22 December 2021

New Liverpool Primary School SSD 10391 – Request for Information

Attachment A – Detailed Responses

DRAWING TITLE
UNENCUMBERED PLAY & TREE CANOPY

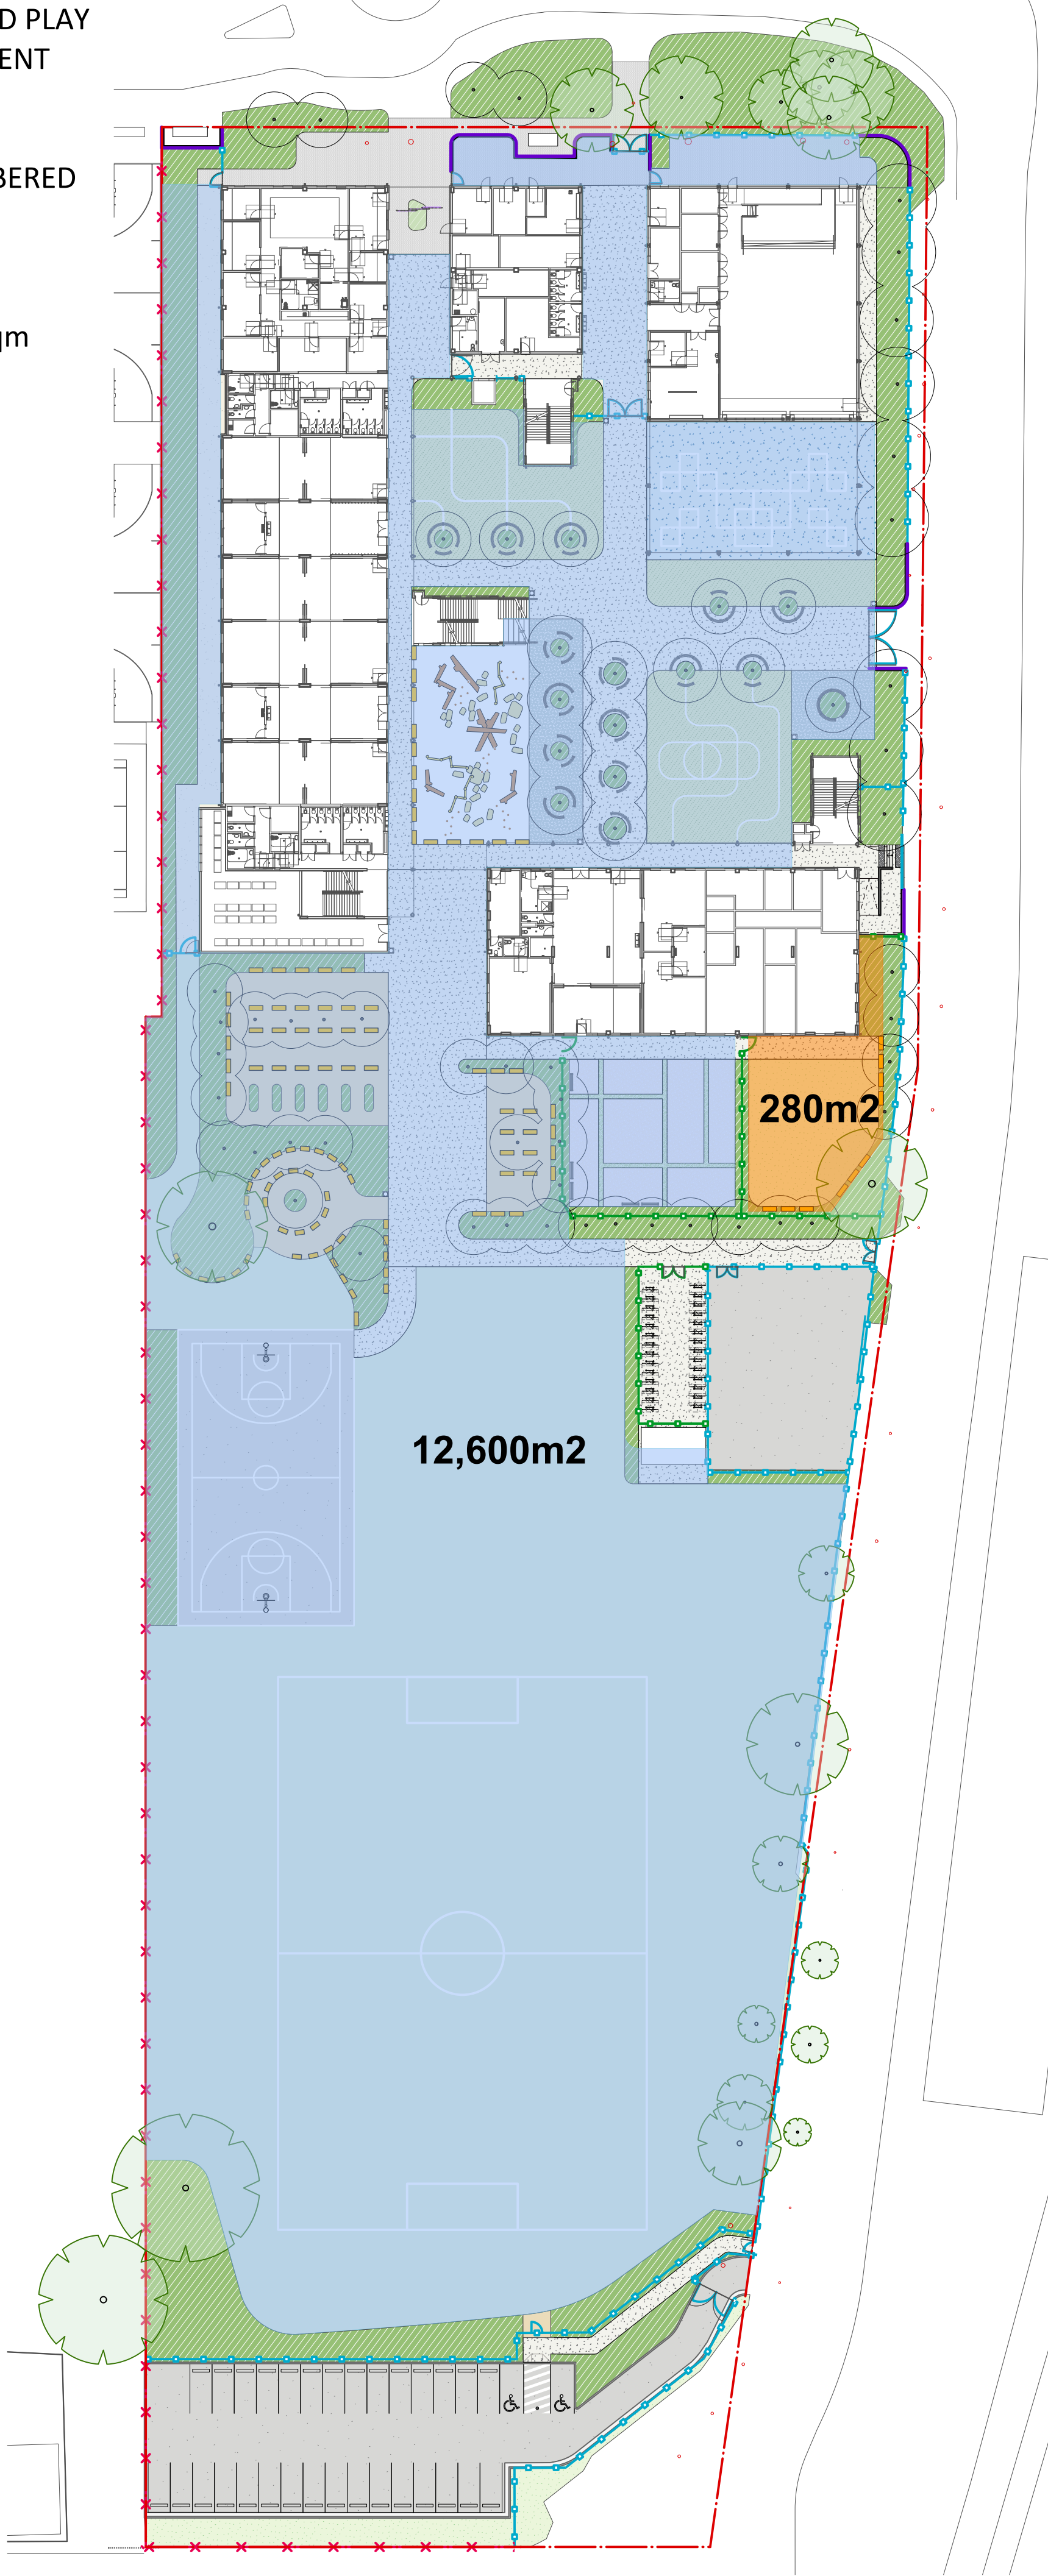
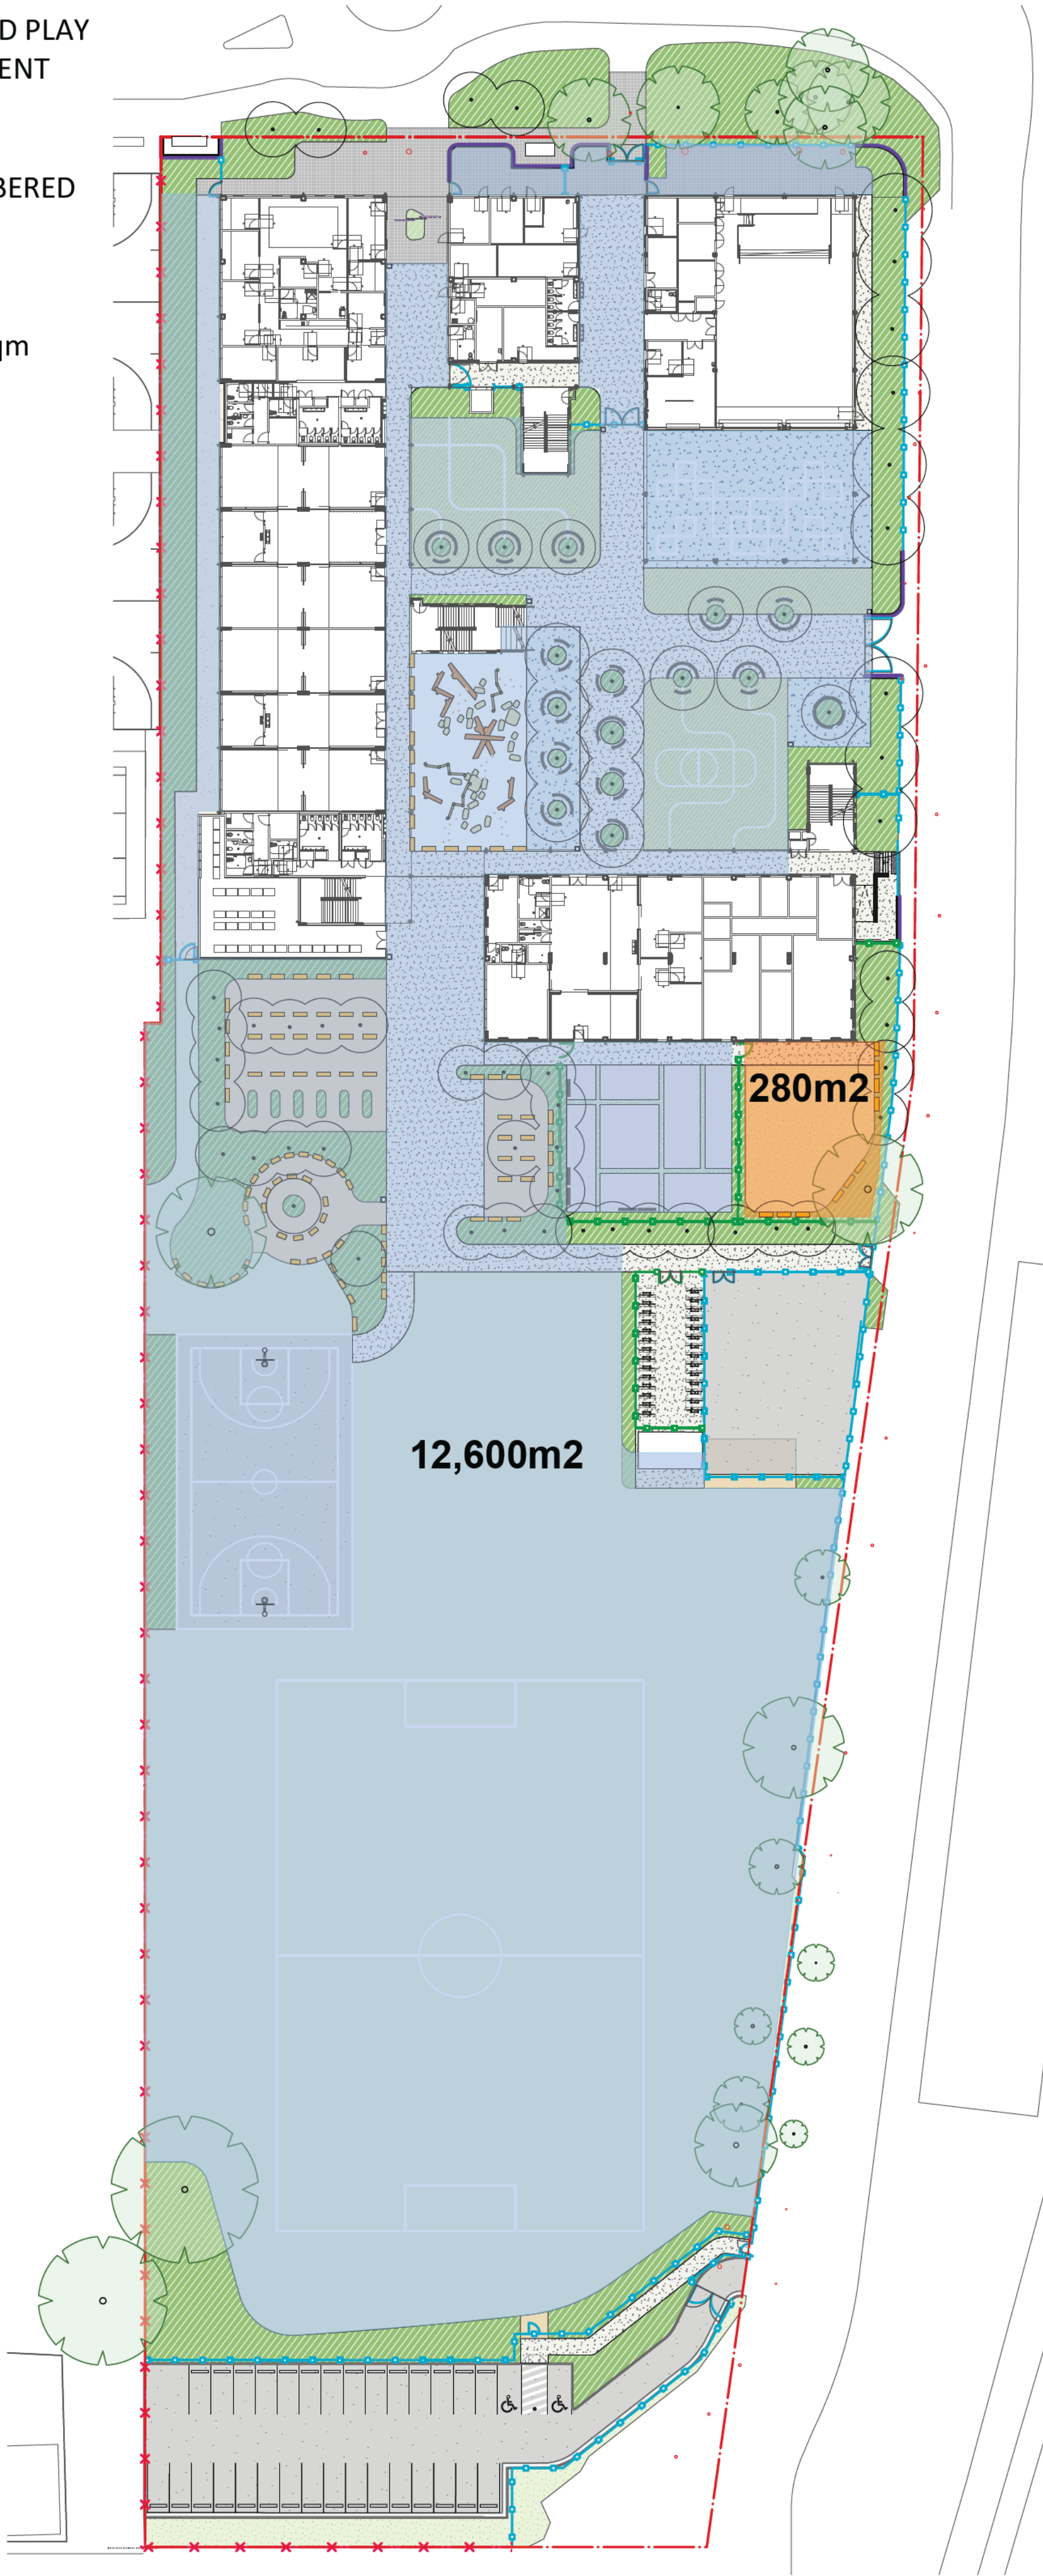
The open space area allocation for preschool students is not clear. The Additional Architectural Drawings (submitted with the RTS) show a combined encumbered play area 856sqm for the 'support unit' within the school and the preschool students. This is not accepted, as the preschool play area should be clearly delineated to with the requirements identified in the State Environmental Planning Policy (Educational Establishments and Child Care Facilities) 2017 (Education SEPP). Please submit amended plans, clearly delineating the open space for the preschool children and demonstrating compliance with the relevant guidelines.	A revised drawing is provided at Attachment D which indicates the play space for the support unit and for the preschool. 7m ² of unencumbered play space is provided per student, or 280m ² in total, which is compliant with the open space requirements of 7m ² per student.
The location of the trees in the submitted drawings NLPS-AR-DRG-SSD-0202 and NLPS-LA-SD-0101-DRG(05) are inconsistent. Please submit consistent landscape and architectural plans.	These plans have been amended and are included at Attachment B and Attachment C .
